## DEVELOPMENT HEARING OFFICER

**Project Number:** PR-2023-008085

**Project Name:** Spanish Walk Subdivision – 410 Camino Espanol

*Preliminary Plat (SD-2023-00187), Vacation of Easement (SD-2023-00189), Waiver to DPM (VA-2023-00310)*

04-18-2024 REV

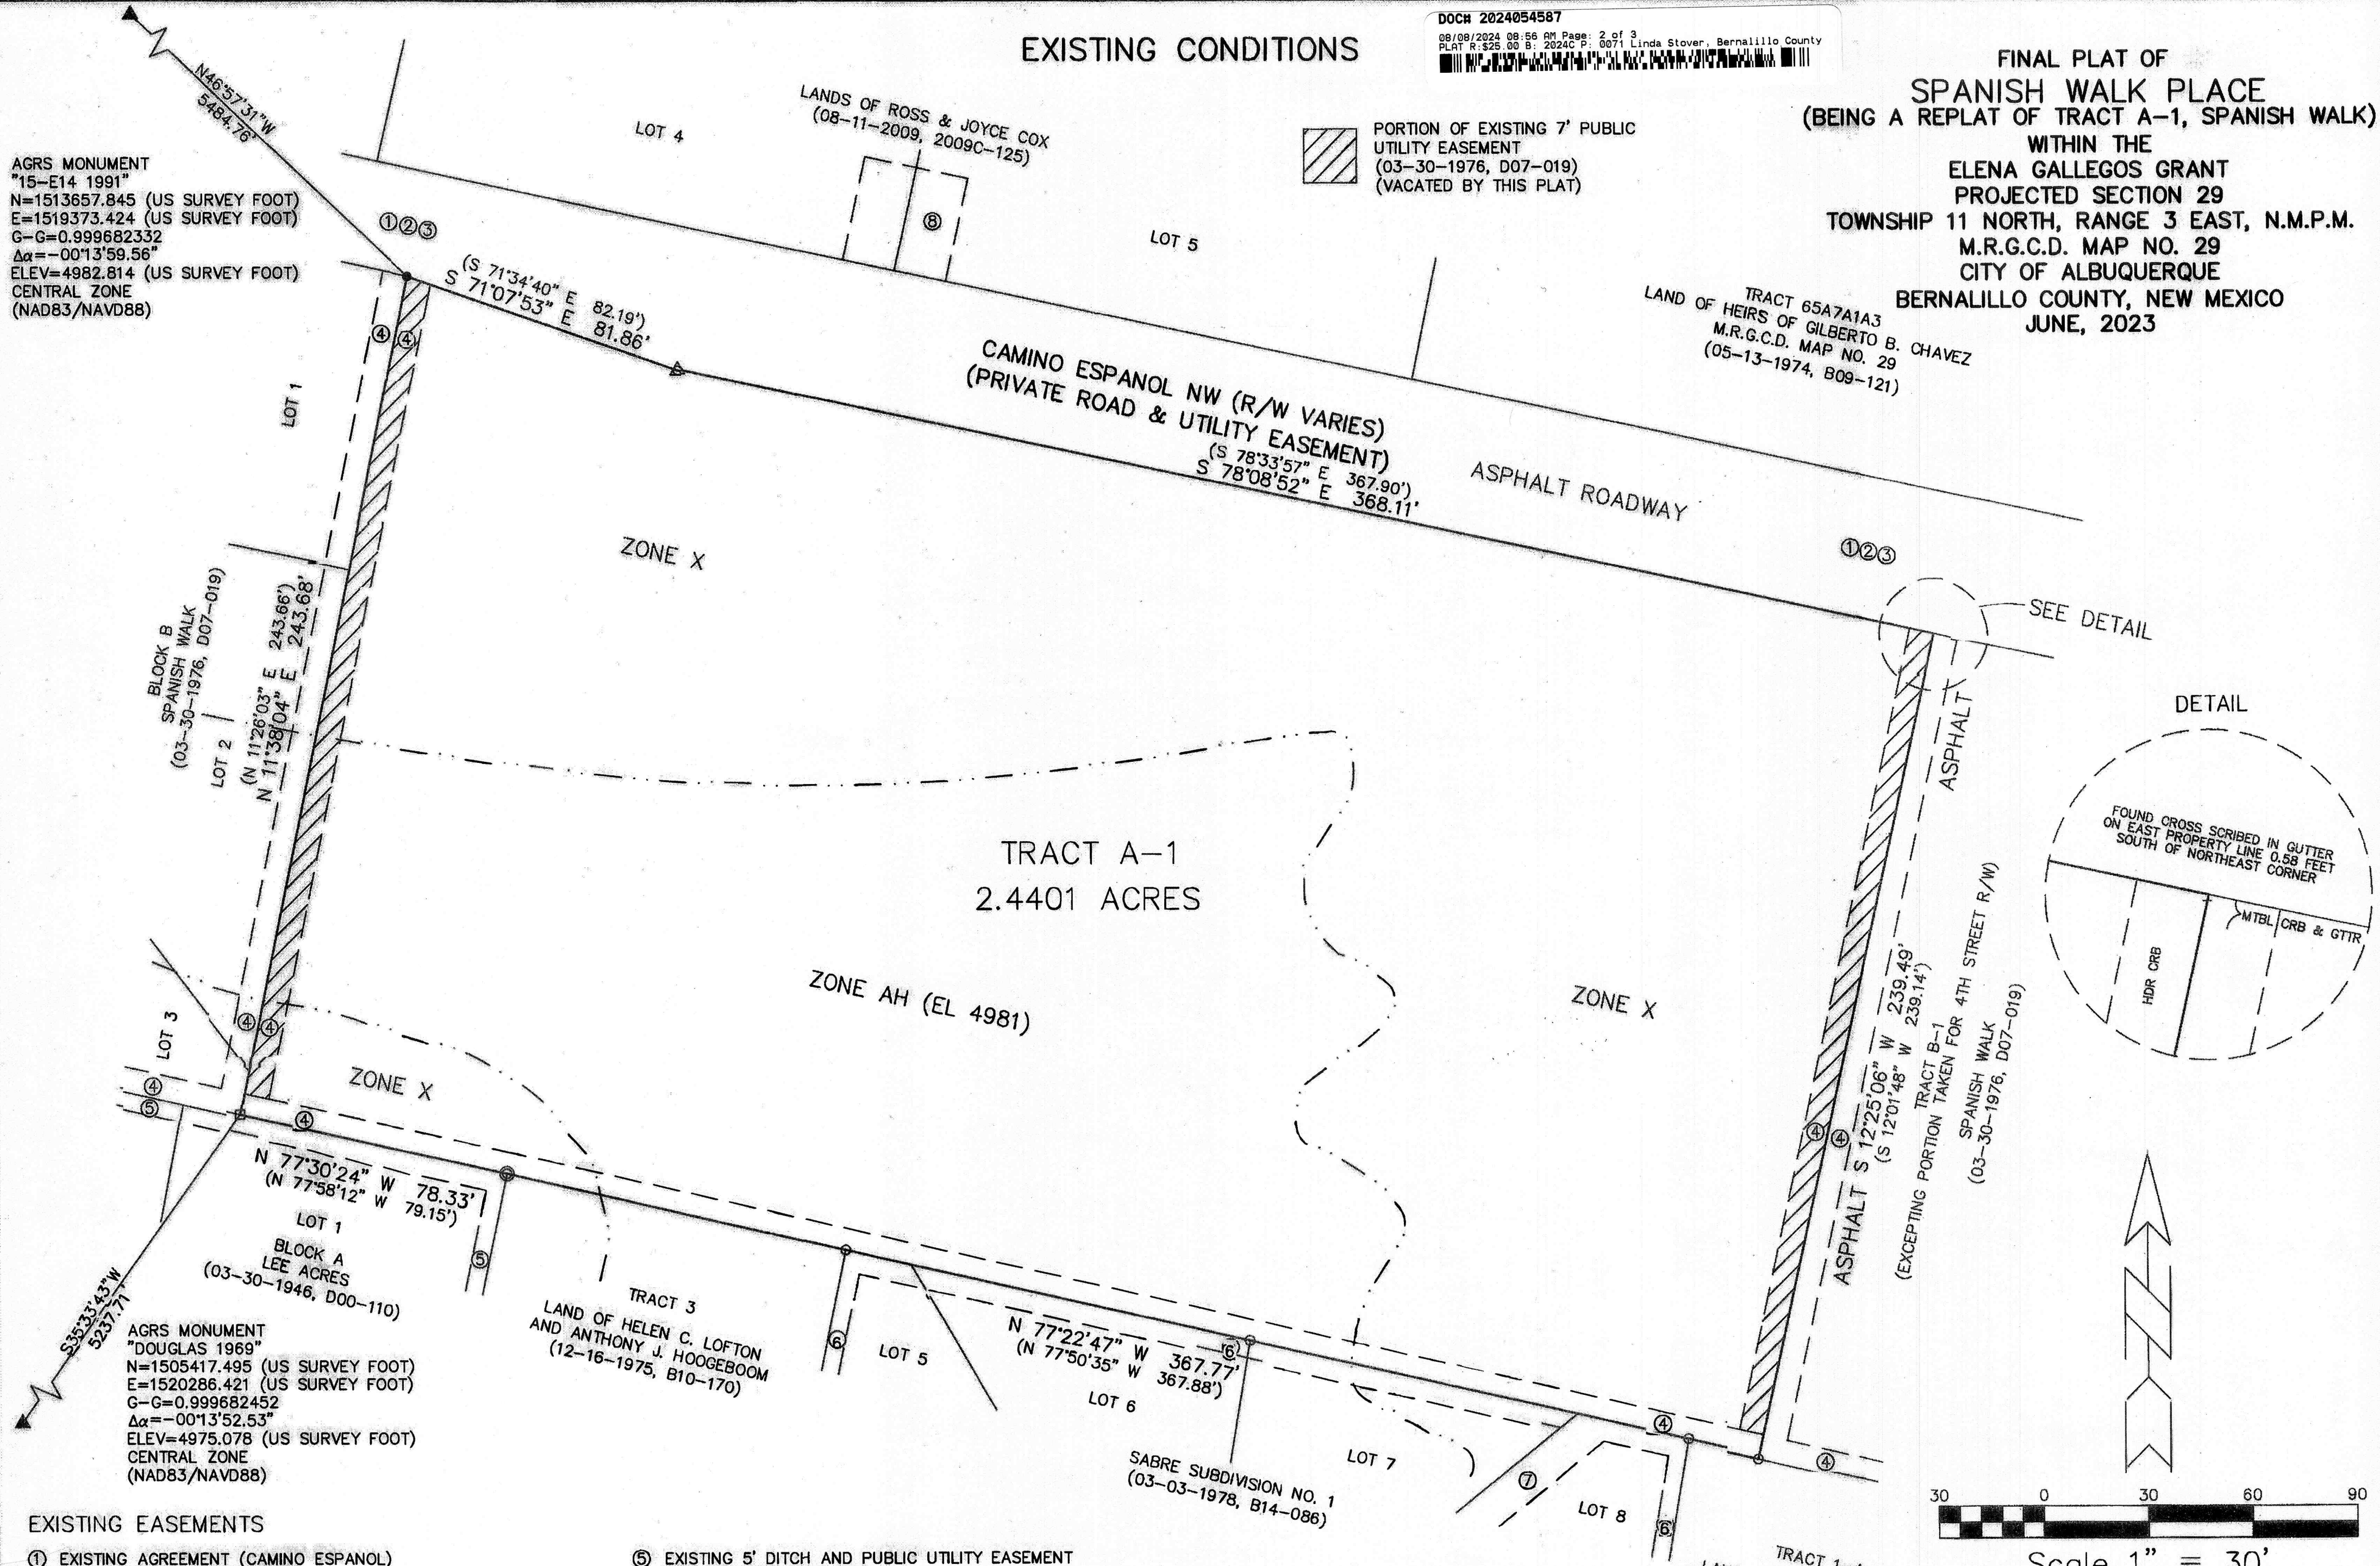
1. Please update Easement Note #10 to state PUBLIC water and PUBLIC sanitary sewer.
2. Add the following note to the cover sheet. If the need to provide non-exclusive is necessary, please discuss with Utility Development on how to manage the language below. (Note needs to be on the cover)

#### ***ABCWUA Public Water & Sanitary Sewer Easements***

***Albuquerque Bernalillo County Water Utility Authority (ABCWUA) is granted perpetual, exclusive easement(s) in gross in the dimensions noted on this plat for the construction, installation, maintenance, repair, modification, replacement and operation of public water and sanitary lines, equipment and facilities reasonably necessary to provide service together with free access on and over the easement and the right to remove trees, shrubs, undergrowth and any other obstacles, modifications, or structures which interfere with use of the easement.***

06-30-2023 REV	
Drawn By: TA	Date: 06-27-2023
Checked By: TA	Drawing Name: 22105PLT.DWG
Job No.: 22-105	Sheet: 2 of 3

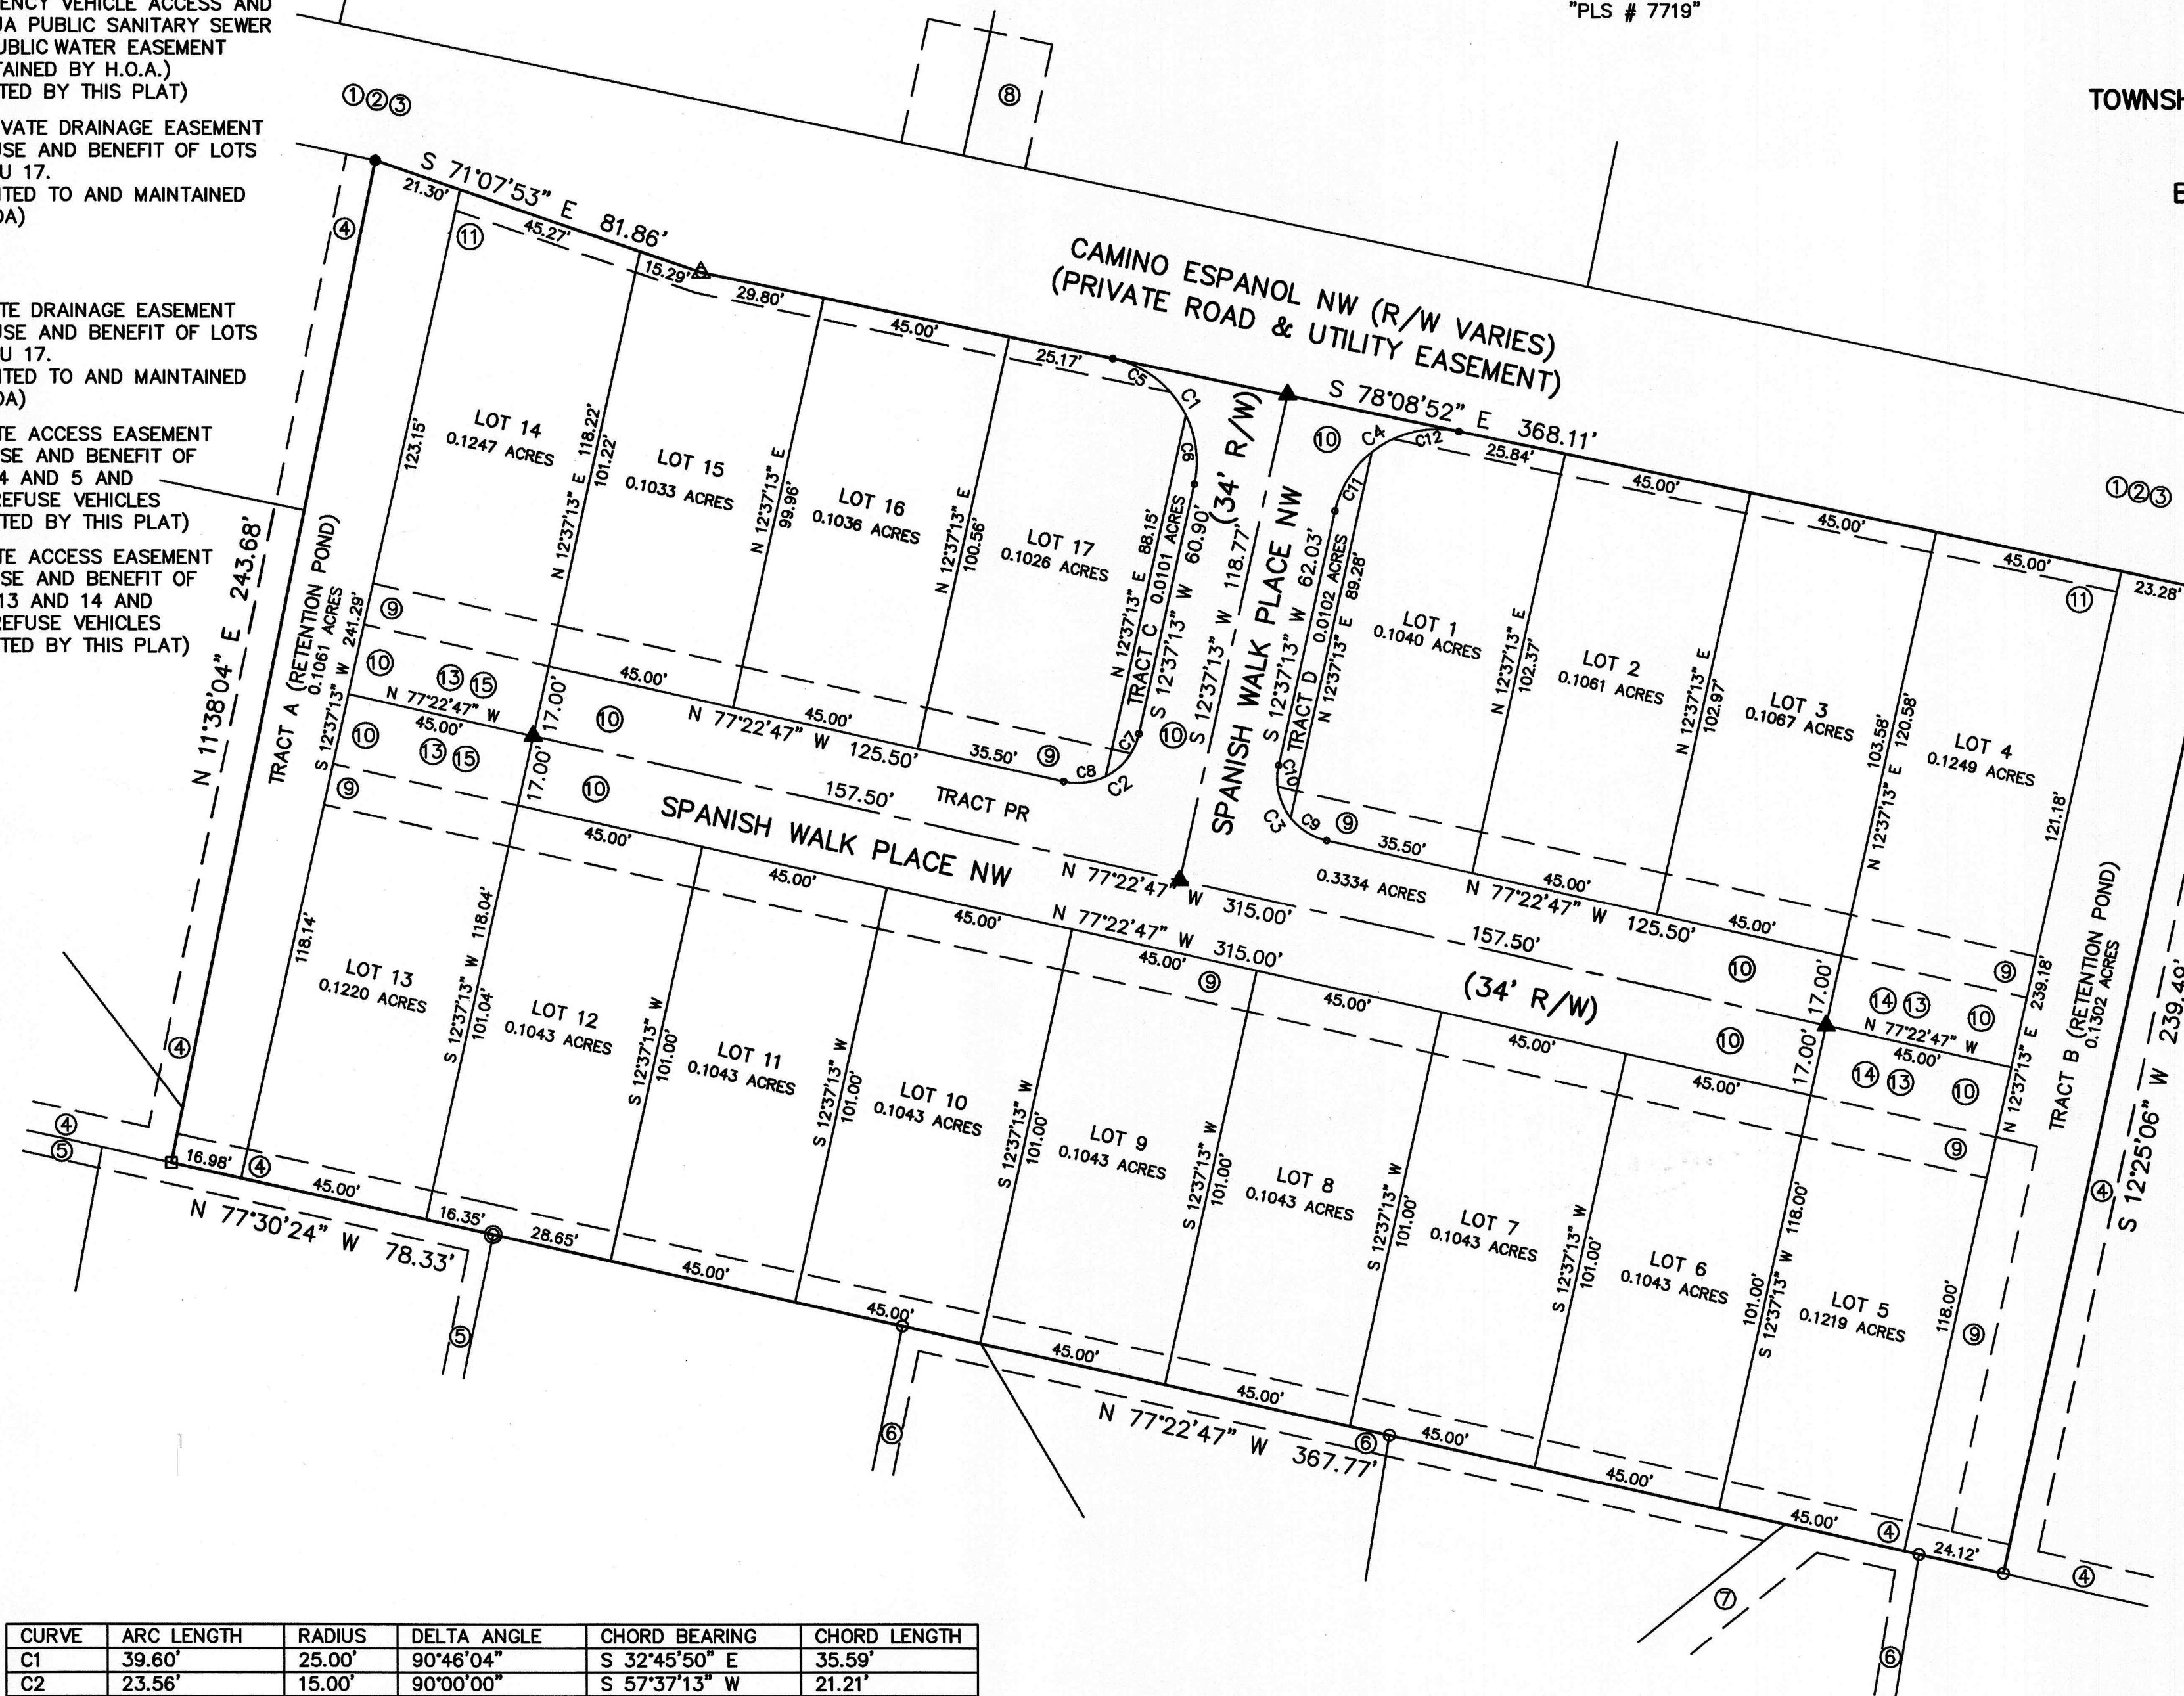
- Per 6-6(M)(3) Review and Decision Criteria, an application for a Vacation of Easement, Private Way, or Public Right-of-way shall be approved if it meets any of the following criteria:
  - 6-6(M)(3)(a) The public welfare does not require that the easement, private way, or public right-of-way be retained.
  - 6-6(M)(3)(b) There is a net benefit to the public welfare because the development made possible by the Vacation is clearly more beneficial to the public welfare than the minor detriment resulting from the Vacation, and there is no convincing evidence that any substantial property right is being abridged against the will of the owner of the right. ~~It appears that the easement marked up as number 4 on the plan is proposed to be vacated. Please clarify the type of this easement and consider providing information regarding this request.~~

*The newly proposed utility easement must be depicted on the Plat.*

The easements to be vacated are 7' Public Utility Easements. They are being replaced by 10' Public Utility Easements that follow the proposed road alignment.
